**From:** [Holly Erdman](#)  
**To:** [Kelly Bacon \(CD\)](#)  
**Subject:** SE-21-00005 Ahlers  
**Date:** Wednesday, April 28, 2021 9:34:45 AM

LOT 4, GRM SHORT PLAT NO. 1
A PORTION OF THE E 1/2 OF THE NW 1/4 OF SECTION 31, TOWNSHIP 20 NORTH, RANGE 16 EAST, W.M.,
KITITAS COUNTY, WASHINGTON

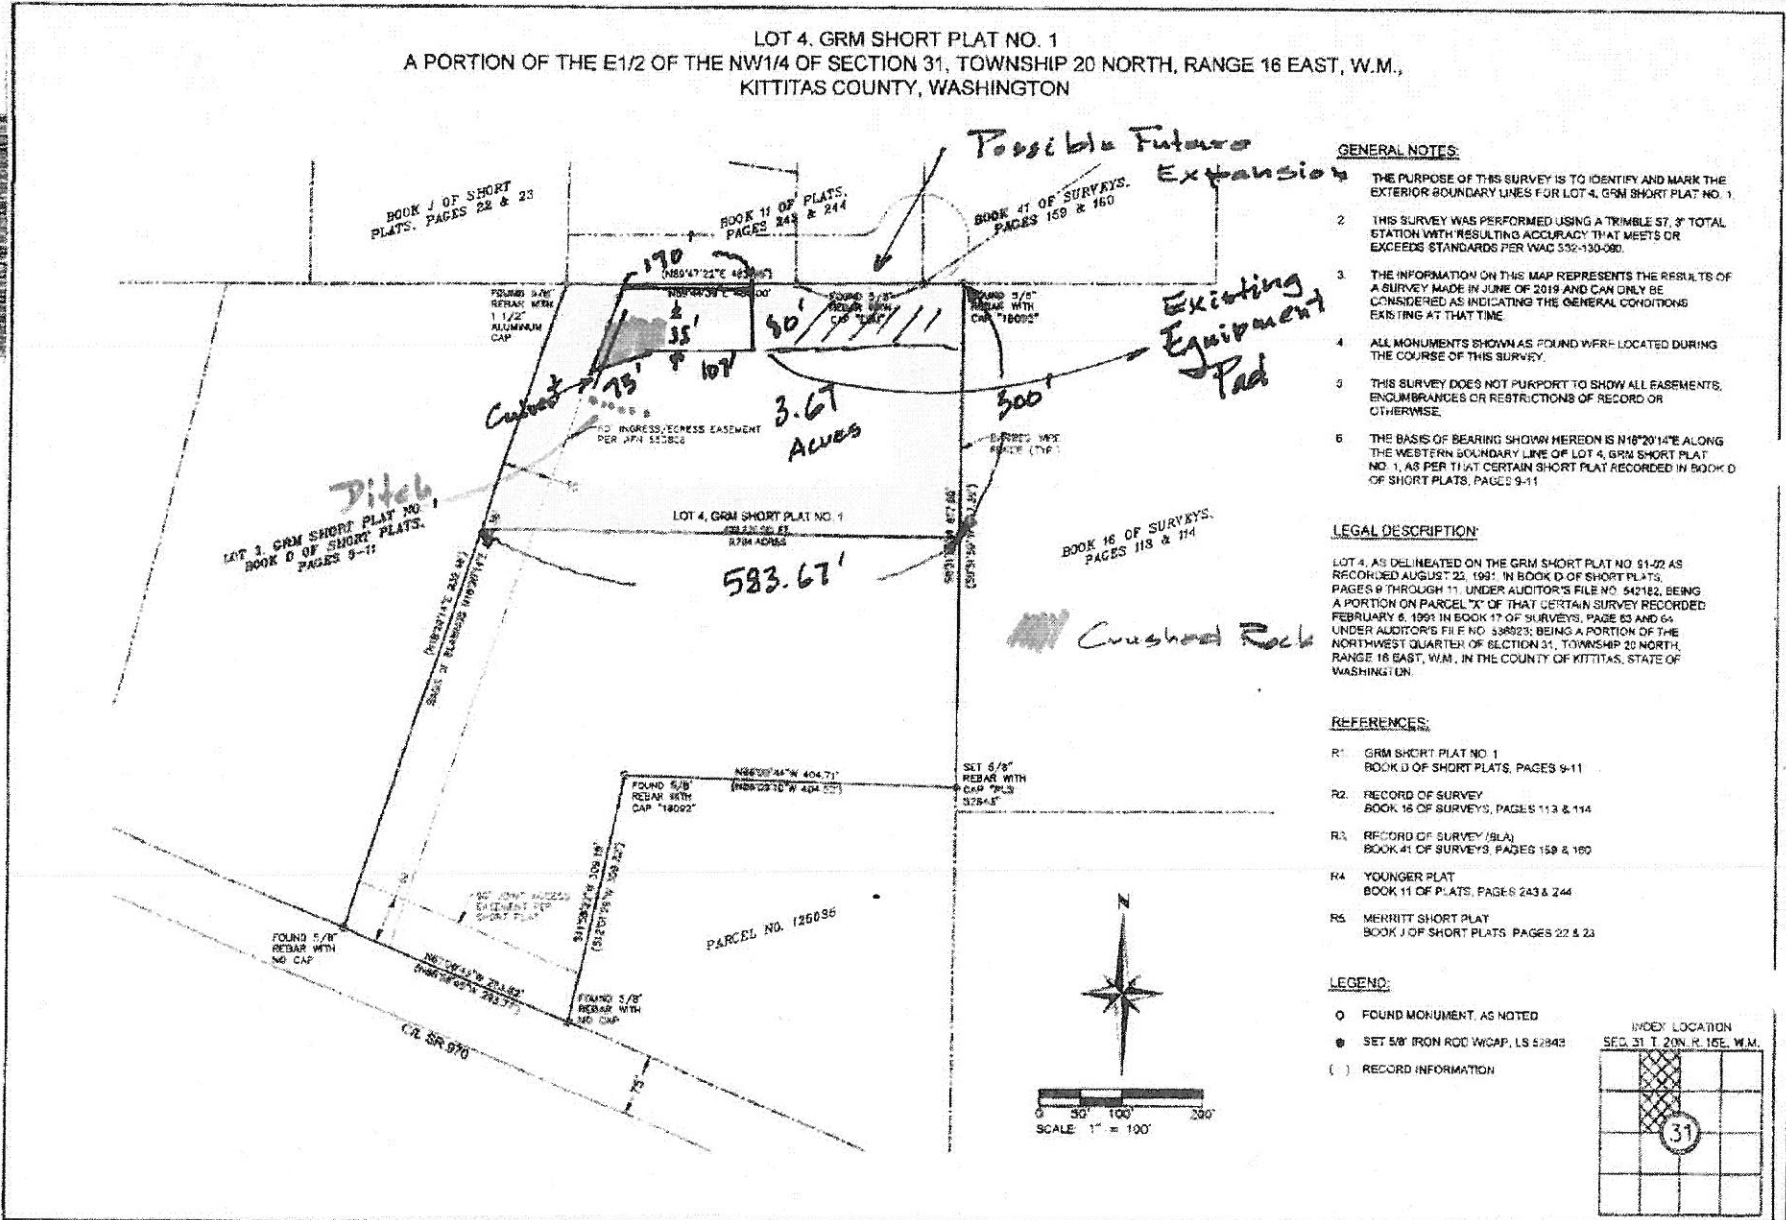
I didn't see any existing wells on the lot. Is that correct?
